The Secretary  
NSW Planning, Industry & Environment

21 February 2020

I refer to the Department's below email and letter of 15 January 2020 regarding modification application (SSD-7348-Mod-3) and a State Significant Development Application (DA) (SSD-10397) for the Oakdale West Estate Stage 2 Development, located at 2 Aldington Road, Kemps Creek in the Penrith City Local Government Area. Submissions need to be made to the Department by 21 February 2020.

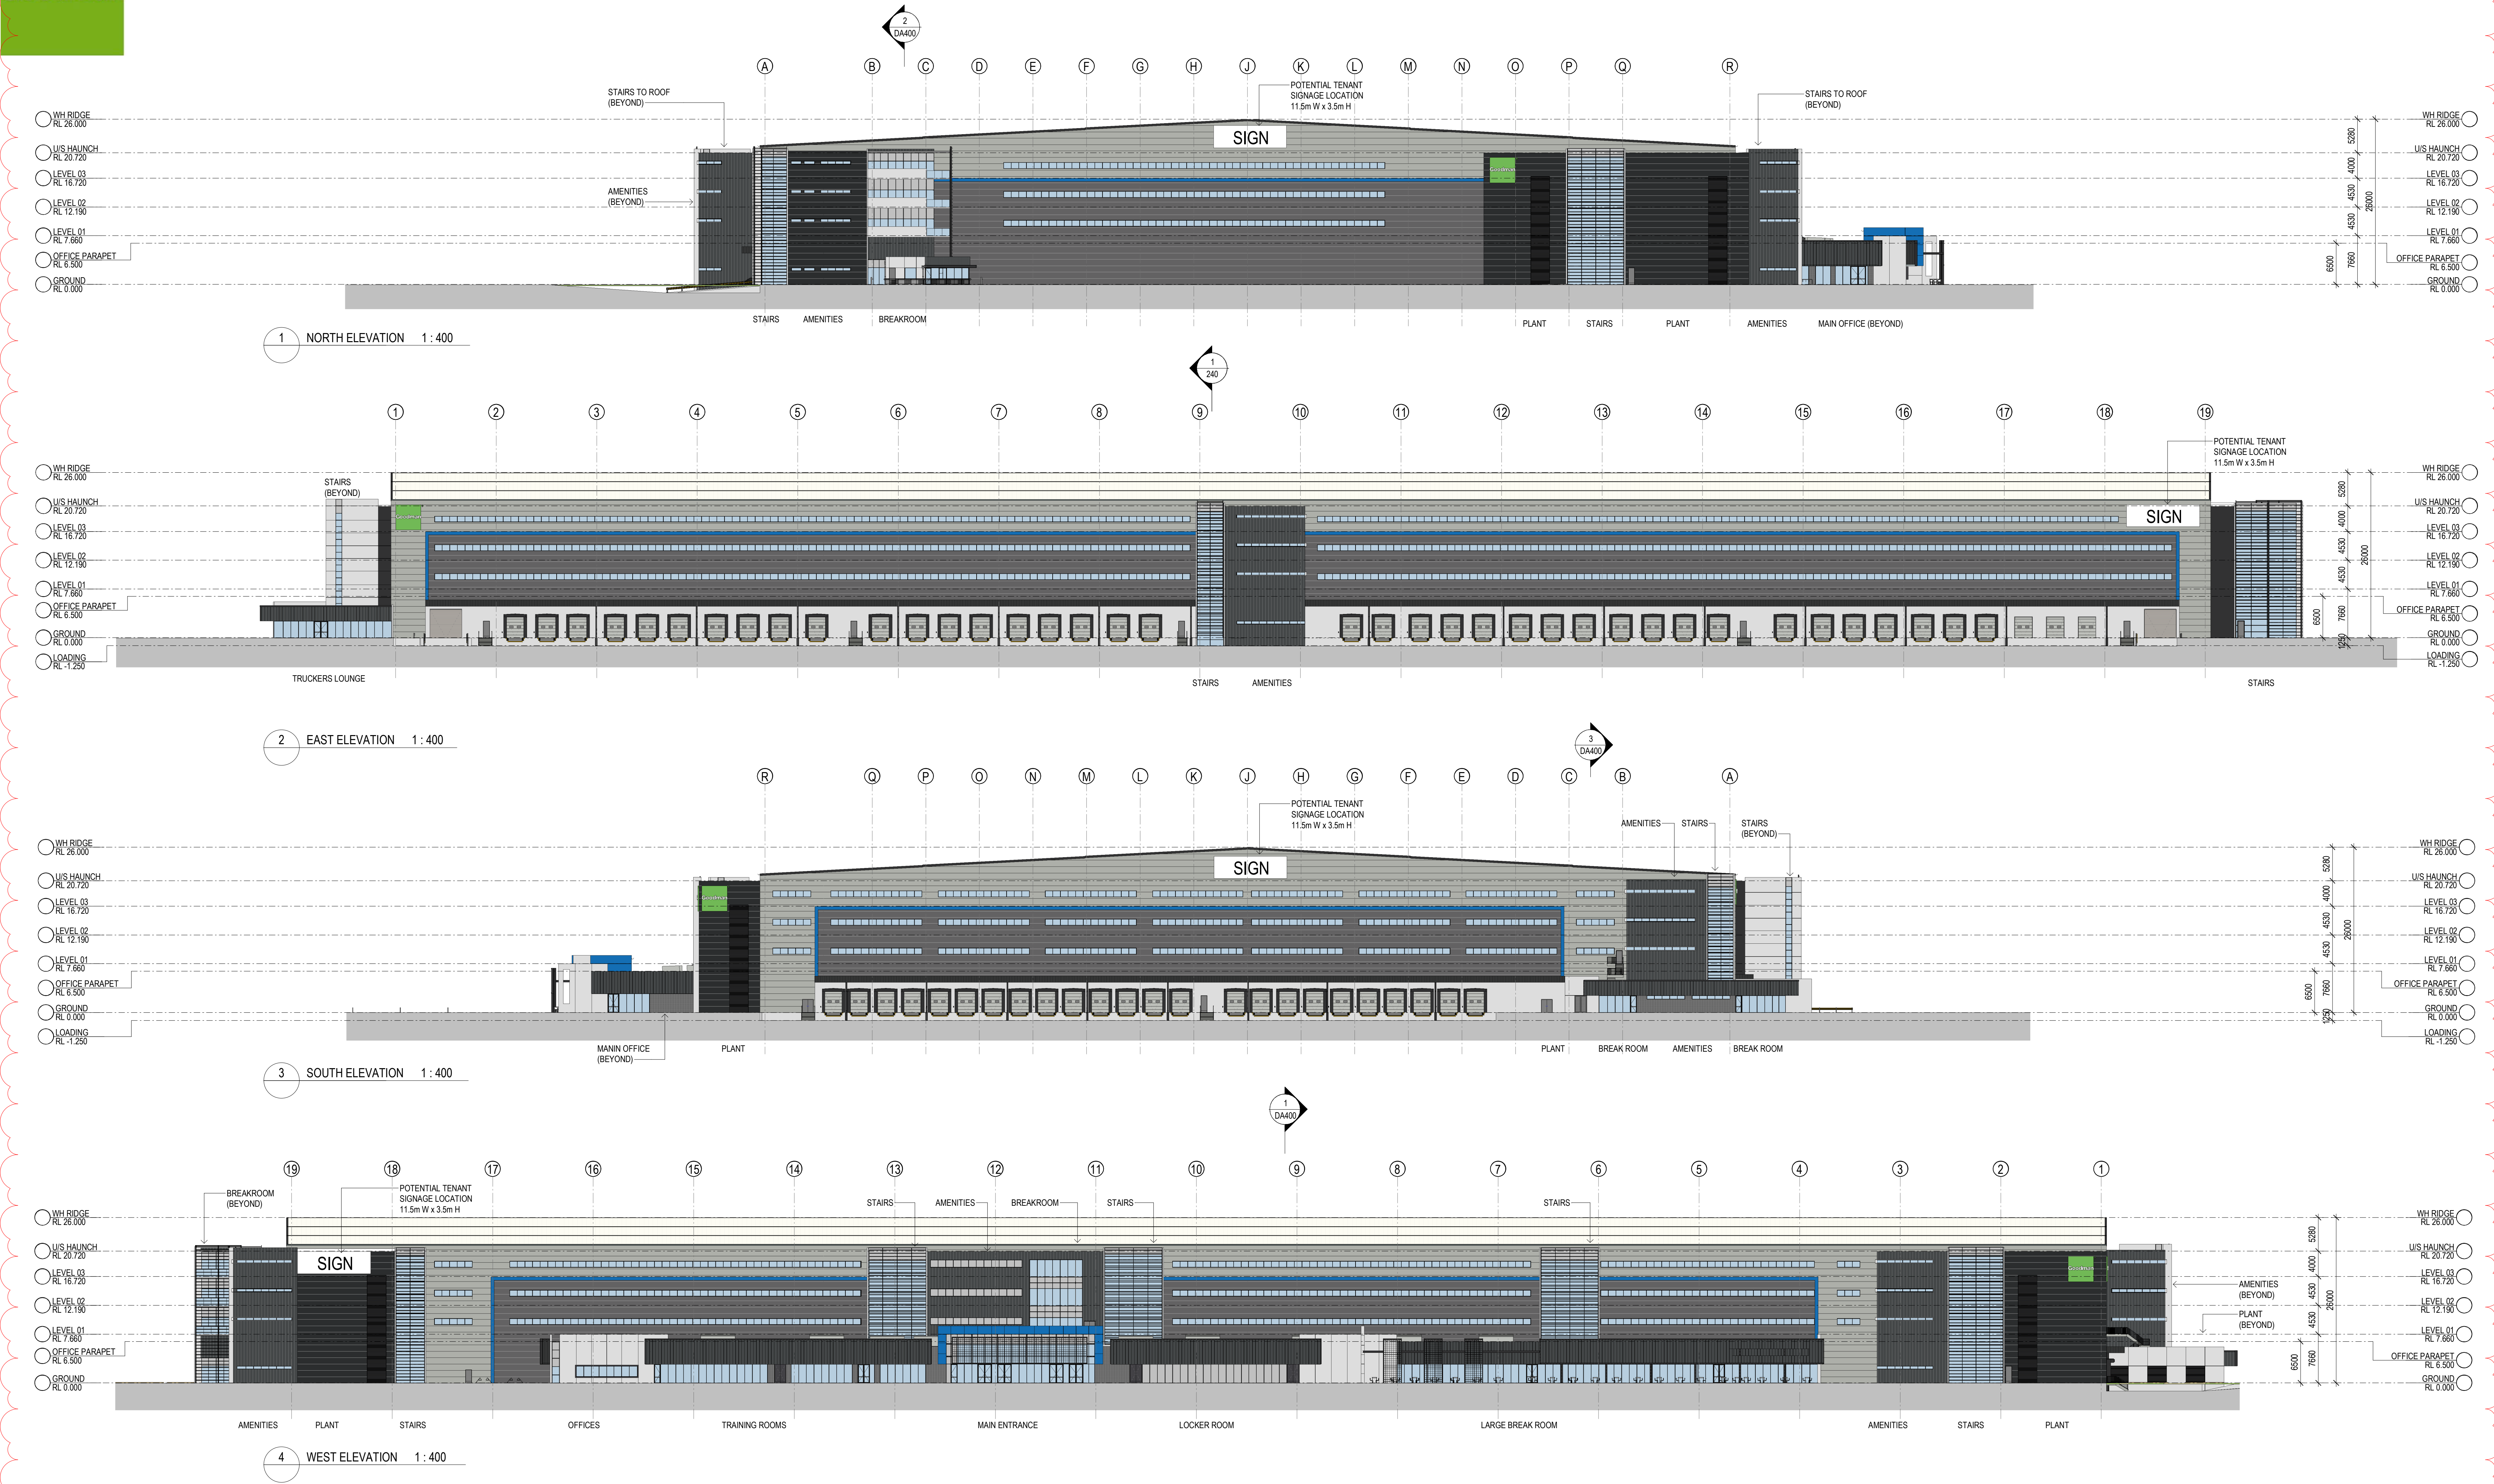
In regard to SSD-10397, as shown in the following extract of the Architectural Plans for Proposed Building 2B, Endeavour Energy has noted that provision has been made for two padmount substation locations each with two transformers within the site with no direct access to an estate / public road.

From Endeavour Energy’s perspective the fact that provision is being made for the substation is a positive. Endeavour Energy’s general requirements is for a padmount substation easement to have a minimum size of 2.75 x 5.5 metres and also have the additional restrictions for fire rating (which usually extends 3 metres horizontally from the base of the substation footing, and 6 metres vertically from the same point and also has regard to any structures etc. attached to the building that may spread a fire) and possibly swimming pools and spas (which in this instance does not appear to be applicable). The easement and restriction/s should not affect any adjoining property (unless supported by an appropriate easement / restriction). The substation should be at ground level and have direct access from a public street (unless provided with a suitable easement for right of access).

Generally it is the Level 3 Accredited Service Provider’s (ASP) responsibility (engaged by the developer) to make sure that the substation location and design complies with Endeavour Energy’s standards the suitability of access, safety clearances, fire ratings, flooding etc. As a condition of the Development Application \ consent the Department should request the submission of documentary evidence from Endeavour Energy confirming that satisfactory arrangements have been made for the connection of electricity and the design requirements for the substation, prior to the release of the Construction Certificate / commencement of works.
